Our Ref: BR/259/10/NMA

Application for a Non-Material Amendment following a grant of planning permission BR/448/04 for 2 No. new windows to the north western elevation, 38 Sudley Road, Bognor Regis

Proposed South East Elevation
Scale 1:100

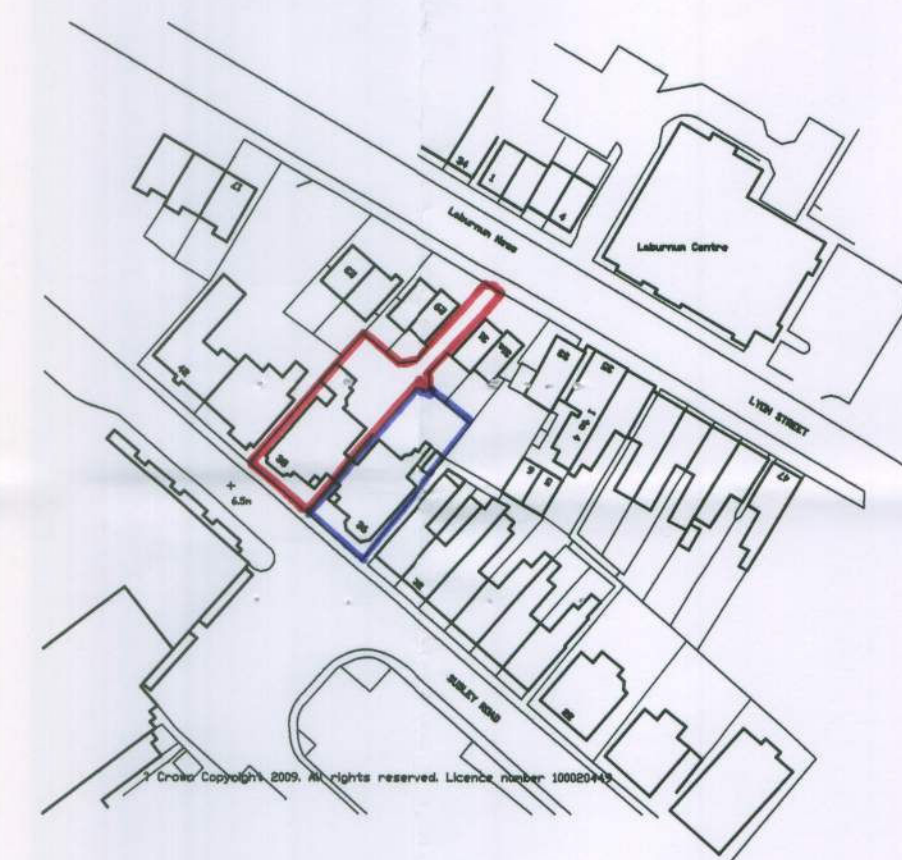
Thank you for your letter and enclosures regarding the above, received on 31st August 2010. Unfortunately I must advise that the proposed additional windows on the north western elevation (labelled incorrectly as south eastern elevation, as confirmed in our telephone conversation of 13th September 2010) of Drawing No. 1187/P40, cannot be accepted as a Non-Material Amendment. This is due to Condition 3 of planning consent BR/448/04, which states that:-

"Notwithstanding the provision of the Town and Country Planning (General Permitted Development) Order 1995, no windows or other openings (other than those shown on the plans hereby approved) shall be formed at first floor level in the northerly side wall of the extension without the prior permission of the Local Planning Authority on an application in that behalf."

Accordingly, without prejudice, I would suggest you submit a revised application for a Variation of Condition for consideration.
